Moorebank Intermodal Precinct East – Stage 2 DEVELOPMENT APPLICATION REVIEW

*Prepared For NSW Department of Planning & Environment
20th November 2017*

1  
0006  
PROPOSED STAGE 2 SITE PLAN  
1 : 2500

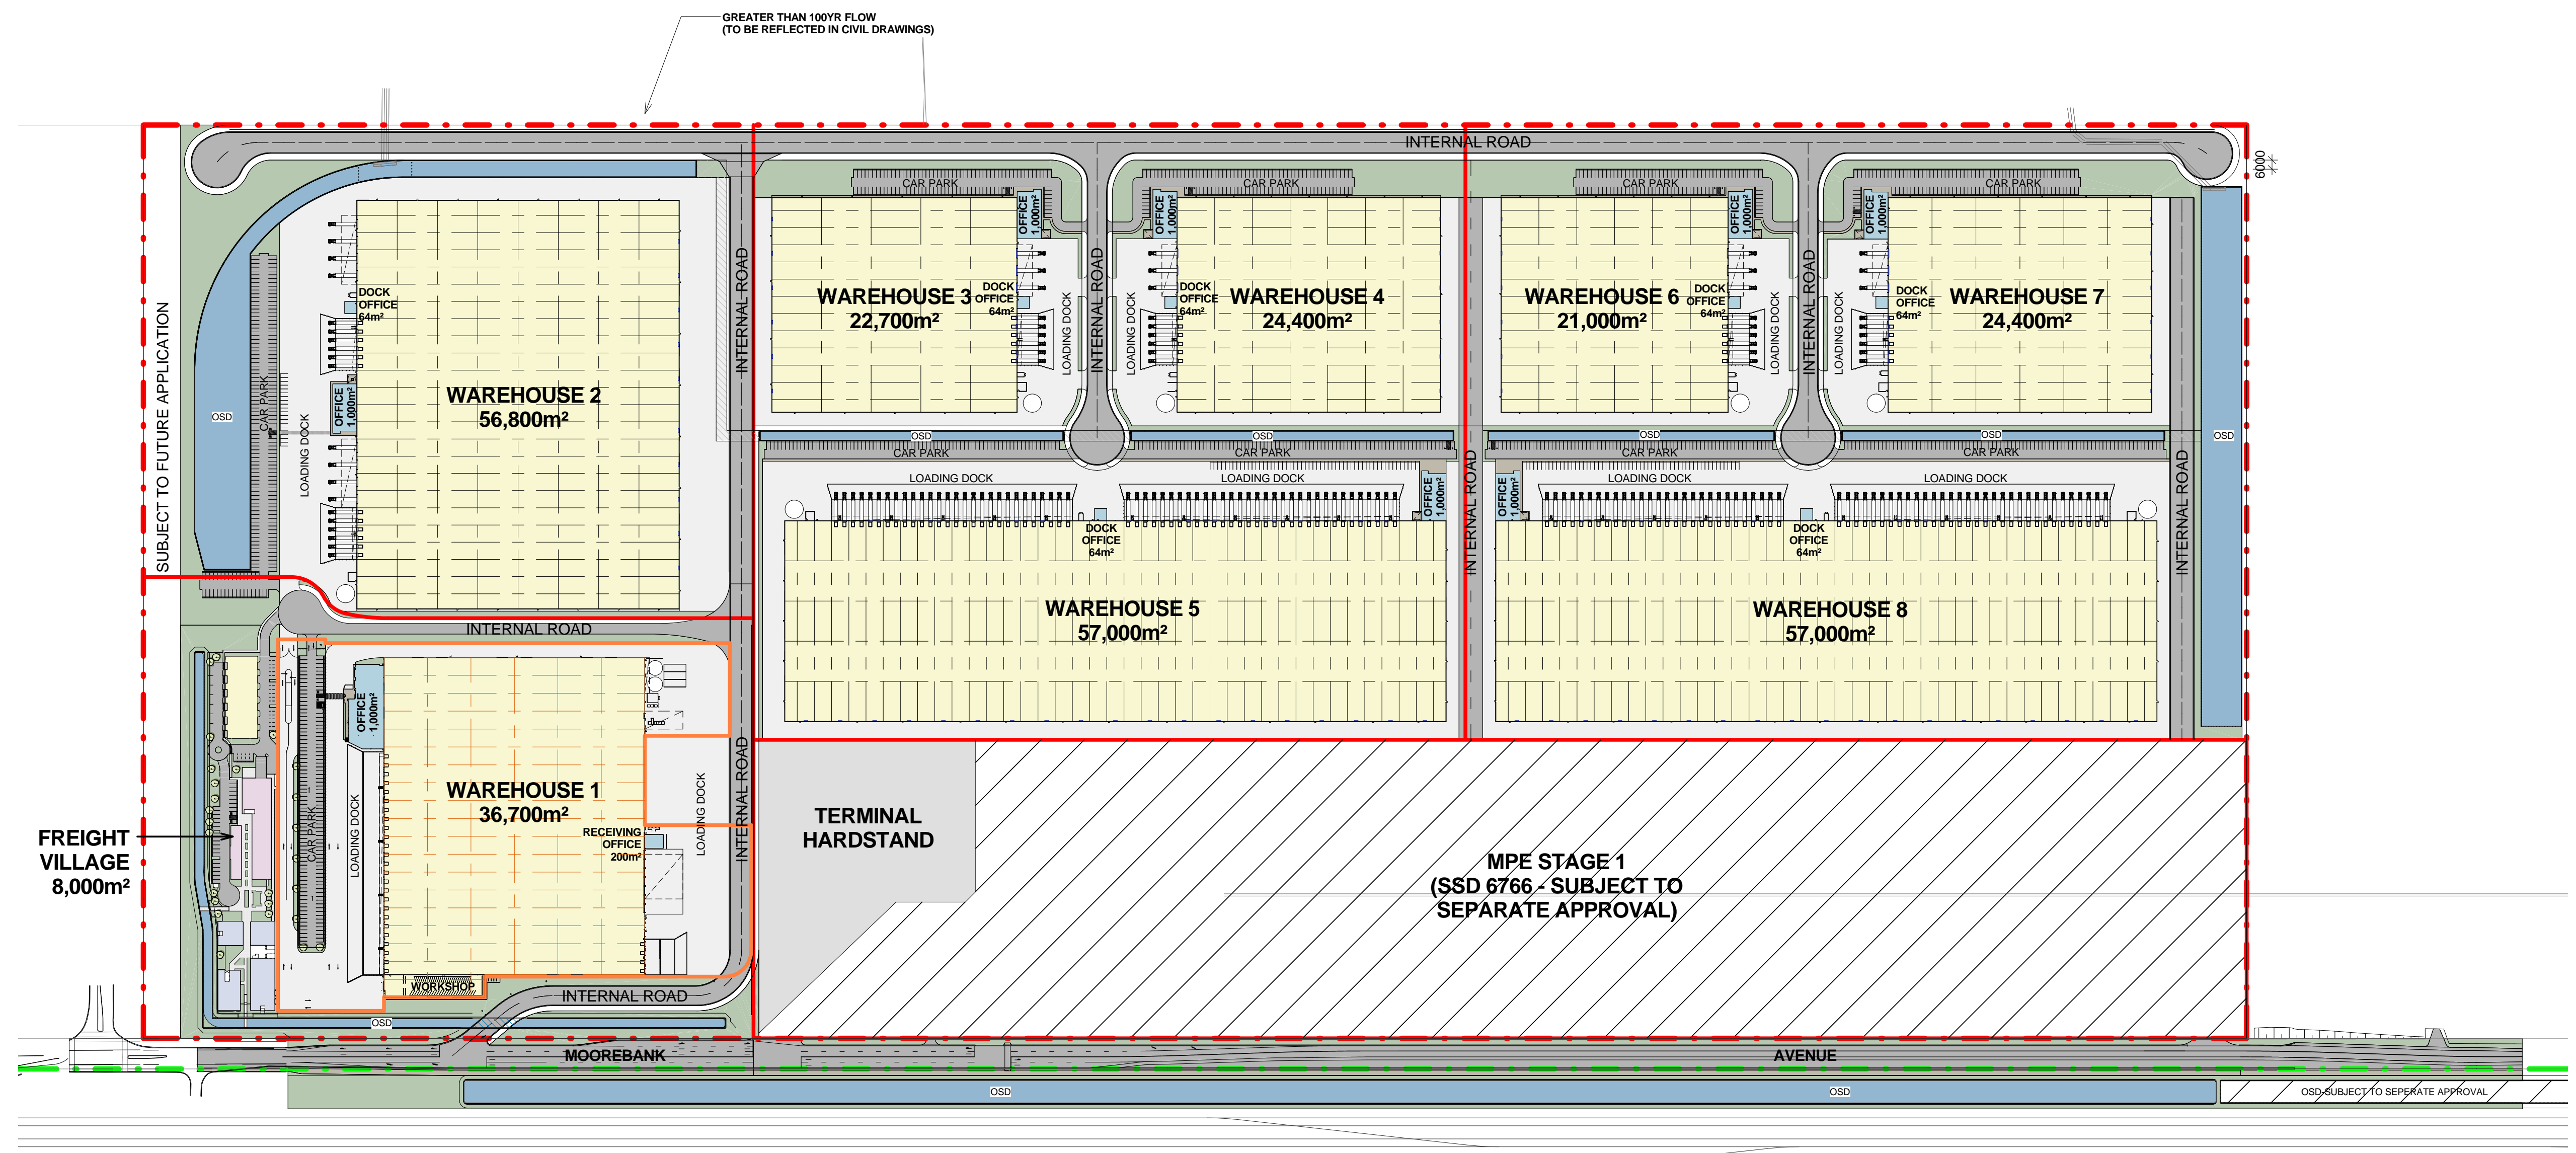
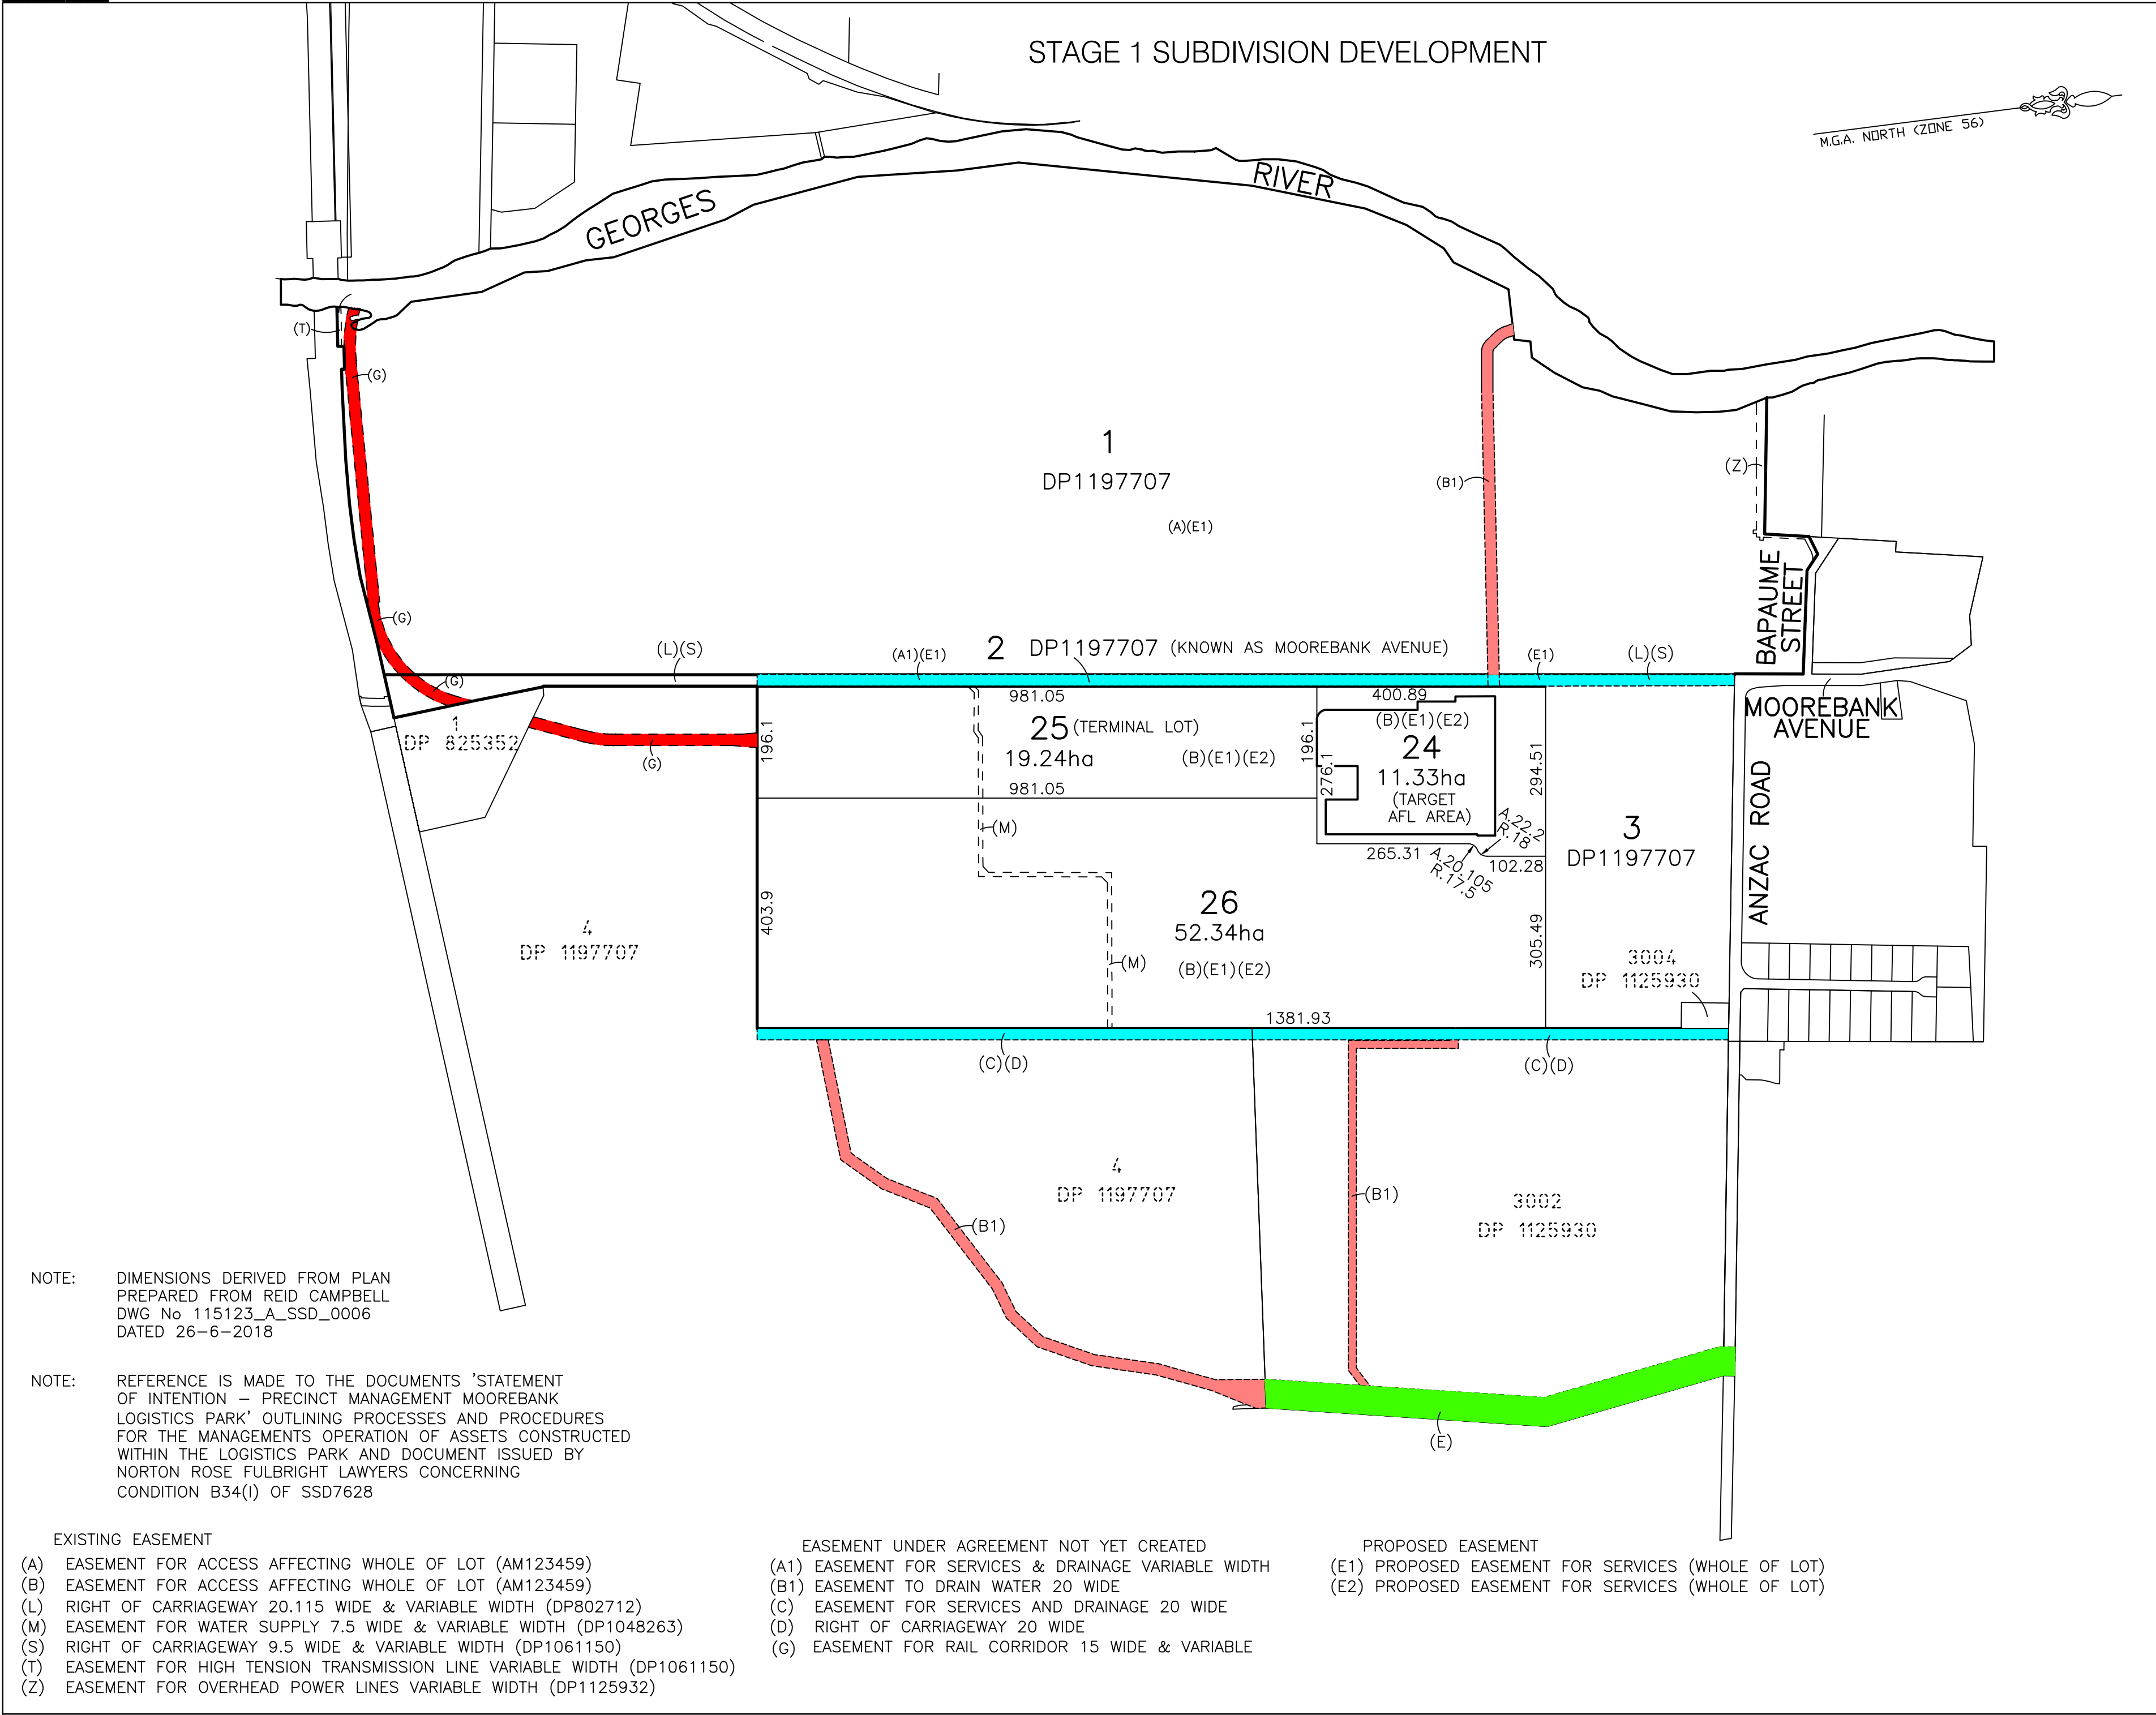
Site Access	OTTIA, Sect 1.5 & 5.2.2, Fig 5-6	<p>It was estimated that approximately 3% of employees will utilise Moorebank Avenue (south of the Proposal site) to travel to / from the site by car.</p> <p>The Proposal site plan indicated that the MPE Stage 2 access is to approach Moorebank Avenue at an approx. 45 degree angle.</p>	<p>The proposed approach angle is likely to make it difficult for drivers to turn right into, and left out of the site.</p> <p>It is recommended that intersection plans be modified to achieve appropriate approach angles in accordance with the <i>Austrroads Guide to Road Design</i>.</p>
